From: Amanda Scholes on behalf of Planning.Responses
Sent: 09 June 2020 10:23
To: Planning Scanning
Subject: FW: A/80/20/NMA Land between New Place Nursey and Arundel Road, Angmering
Attachments: 1917-PL-358 Type 3 Comparative elevations.pdf; 1917-PL-150A Proposed Site Layout (Comparative Layout).pdf

From: Ainara Goikoetxea <[REDACTED]>
Sent: 08 June 2020 18:22
To: Anita Gardner <[REDACTED]>
Subject: Re: A/80/20/NMA Land between New Place Nursey and Arundel Road, Angmering

1917 - PL - 358 -

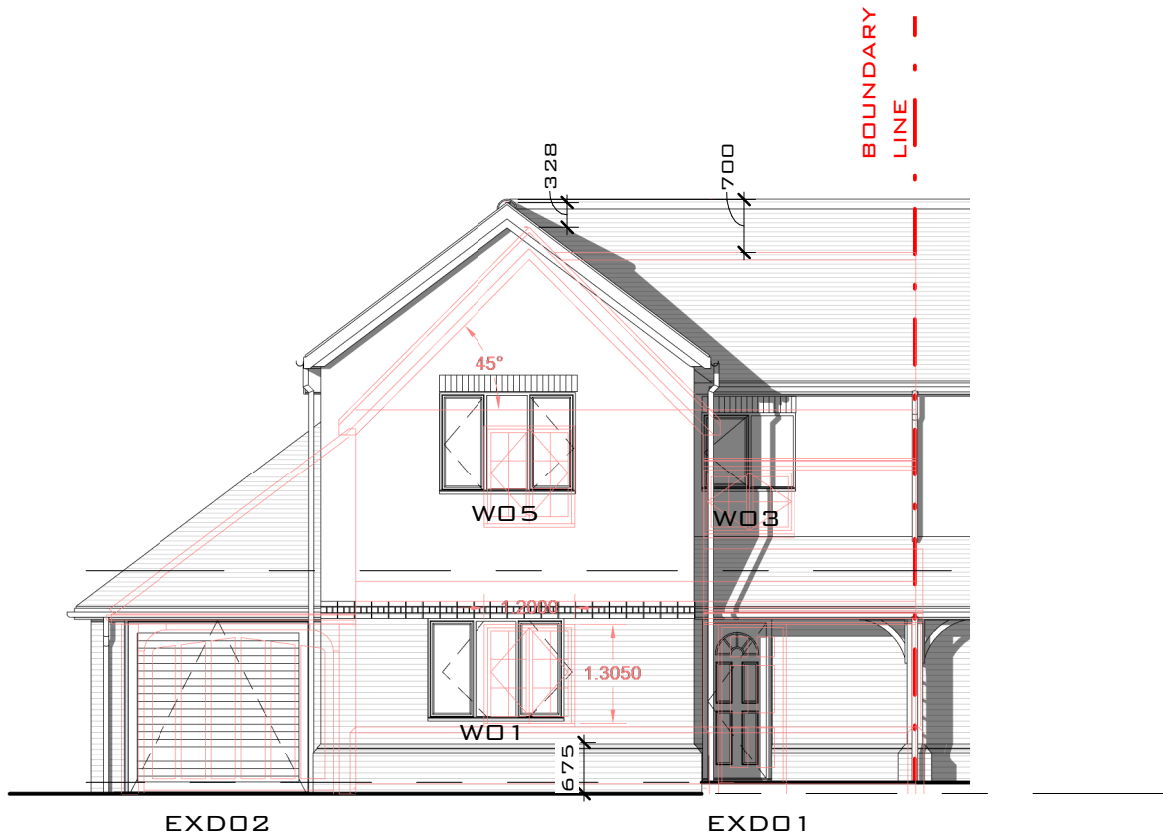
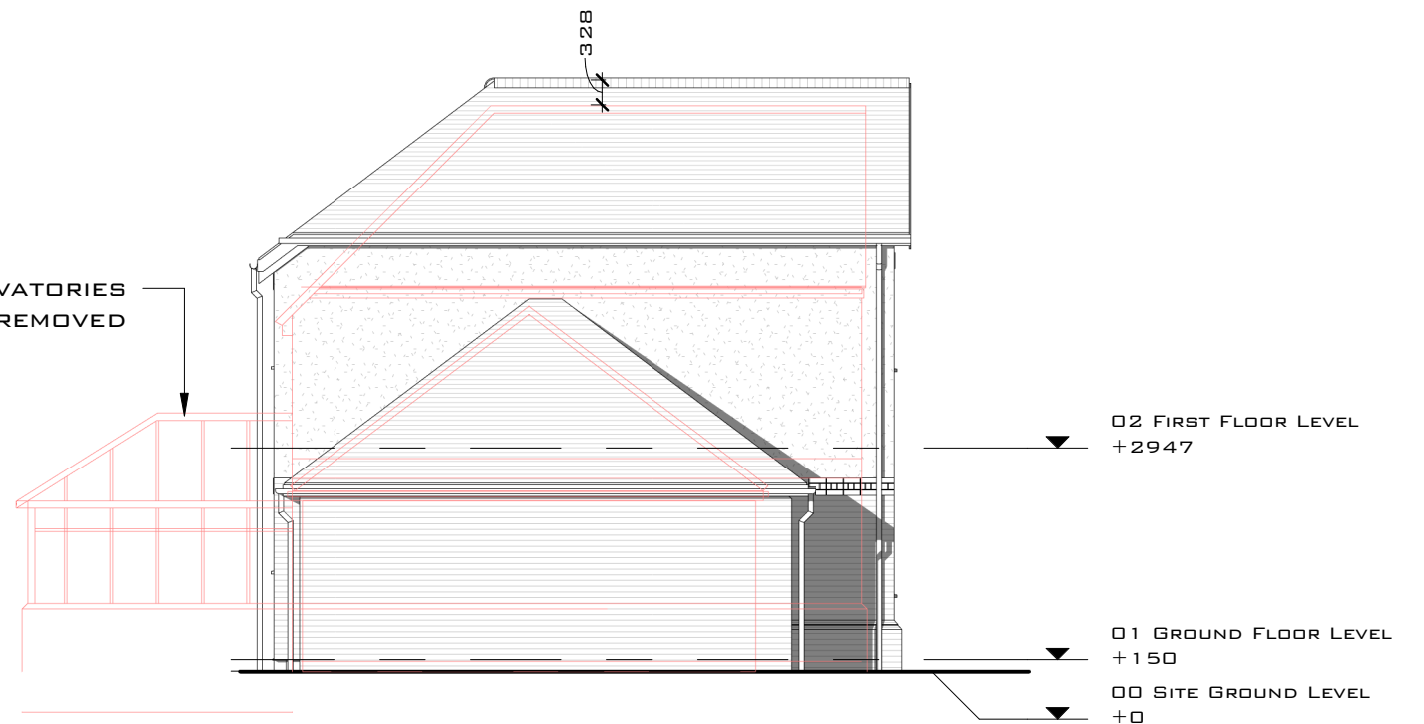
I have received the above application today. In order to progress your application promptly I would appreciate clarification of the changes to the footprint of the dwelling proposed. At the moment I am unable to print plans and scaling from the website is not very accurate. Please can you confirm which plots numbers are affected (I assume it is plots 5 and 6), details of the differences in ridge height (this appears to be 0.7m higher) and dwelling width (appears to be 0.7m wider) and a comparative layout plan of the approved dwelling in relation to the plot boundaries. It looks as though plot 6 is now positioned on the boundary and has been moved towards the rear of the site.

I have also attached an overlapped elevation drawing to show the ridge height increase.
